RE: Sign Permit: SI-14-00001 PSE
Map Number: 17-21-09000-0001
Parcel ID: 480936

Your application for the placement of a sign on Beacon Ridge Road has been **approved** by Kittitas County Community Development Services Planning as submitted. Please be advised that this approval is for the land use activity of sign placement. Approval of a building permit may still be required by the Building Department regarding the design and construction of the sign.

SITE PLAN

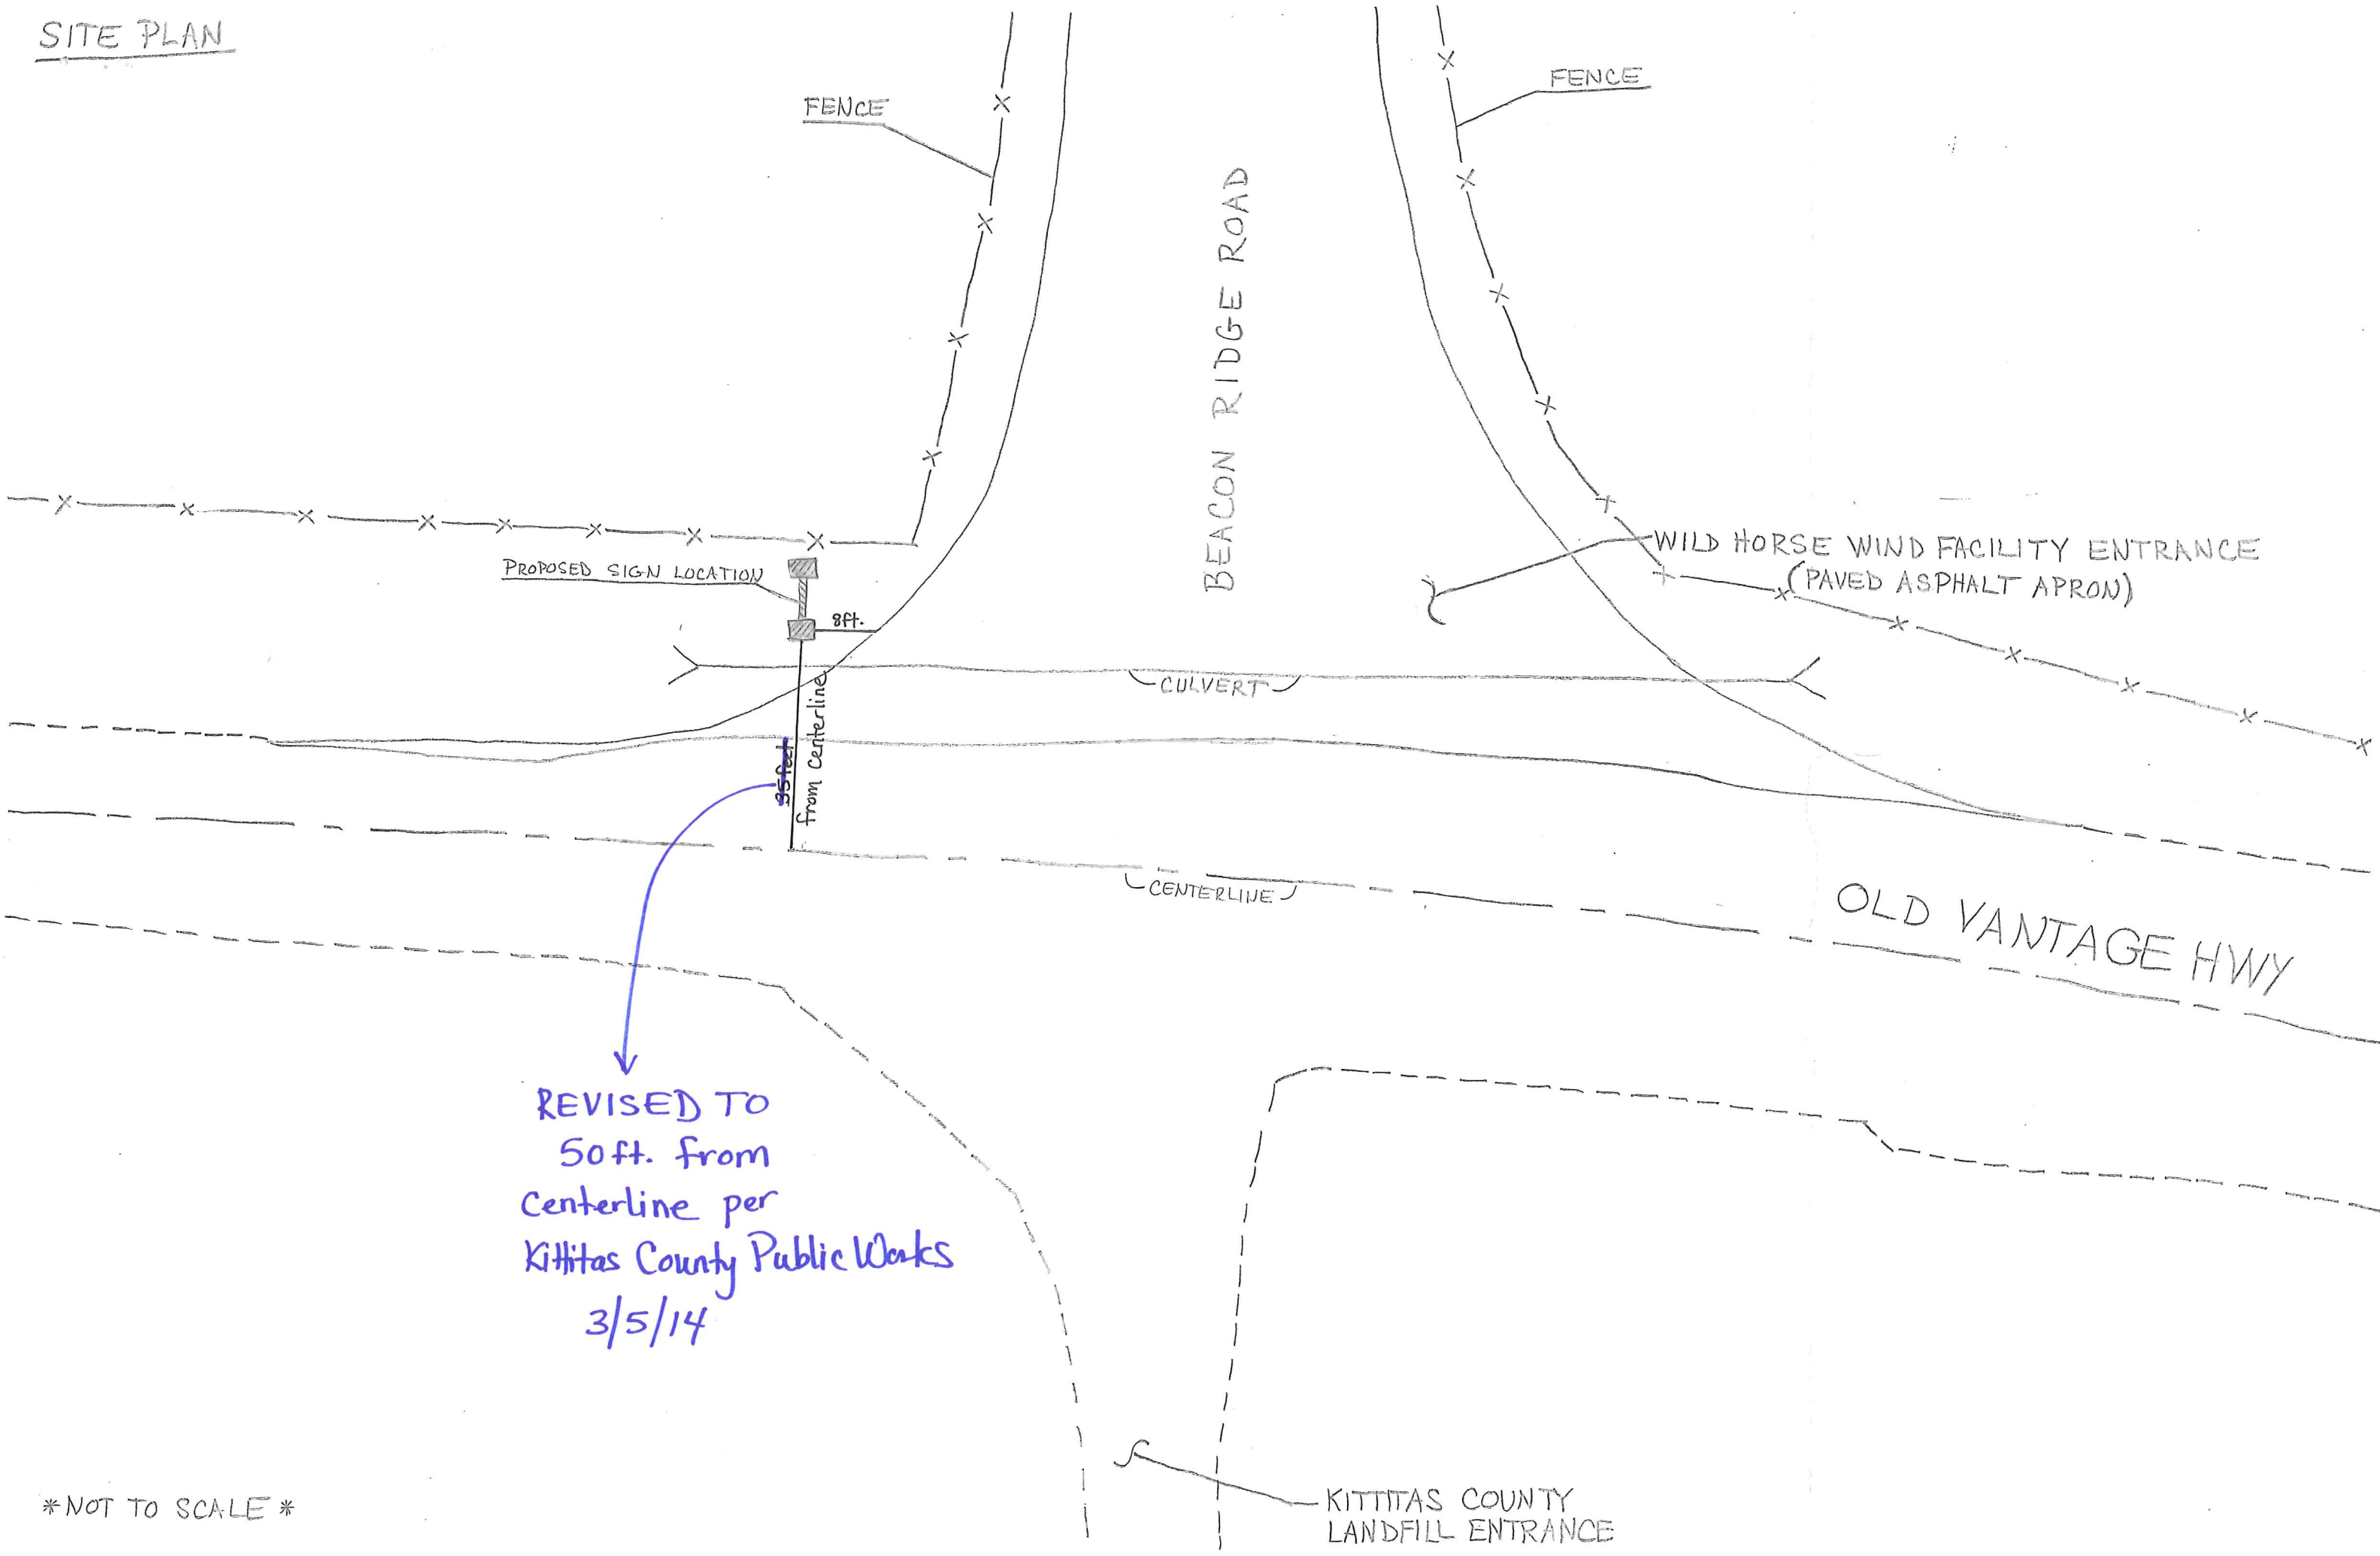
Public Works approves this sign request with the revision showing the sign to be located outside of the right of way.
